2nd December 2020

Planning (Listed Buildings and Conservation Areas) Act 1990 (as amended)

Application No: AB/121/20/L
Site Address: Old Bank House 1 High Street Arundel BN18 9AD
Description of works: Listed building consent for the change of use of existing building from office (Class E) to residential dwelling (Use Class C3) with minor internal layout changes.

No.1  
**EXISTING SOUTH ELEVATION (1:100)**

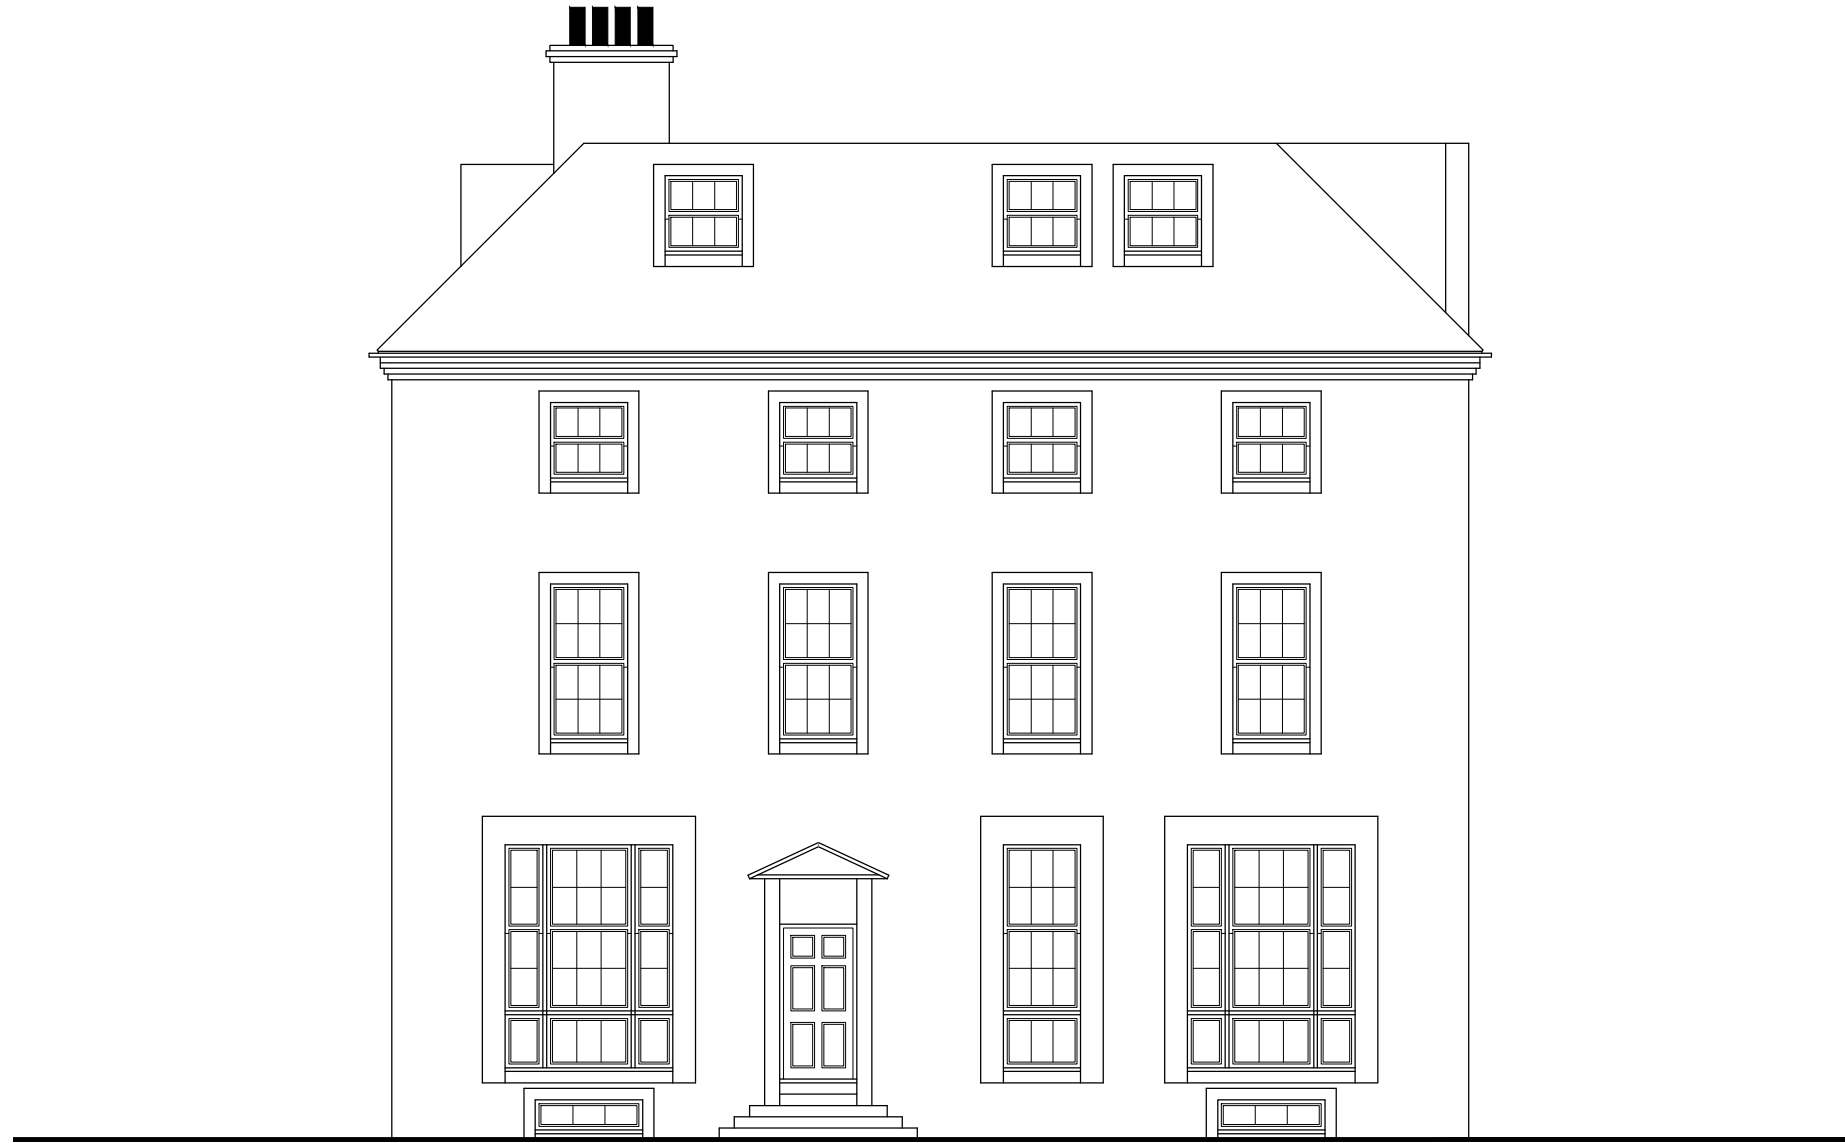
The Panel's understanding is that Listed Building Consent is not required for the change of use but is required for any internal or external alterations. The only significant external alteration shown on the plans is a new door, doorcase and steps, replacing a window on the south elevation of 3, High Street which, in any event, is not part of the application site.
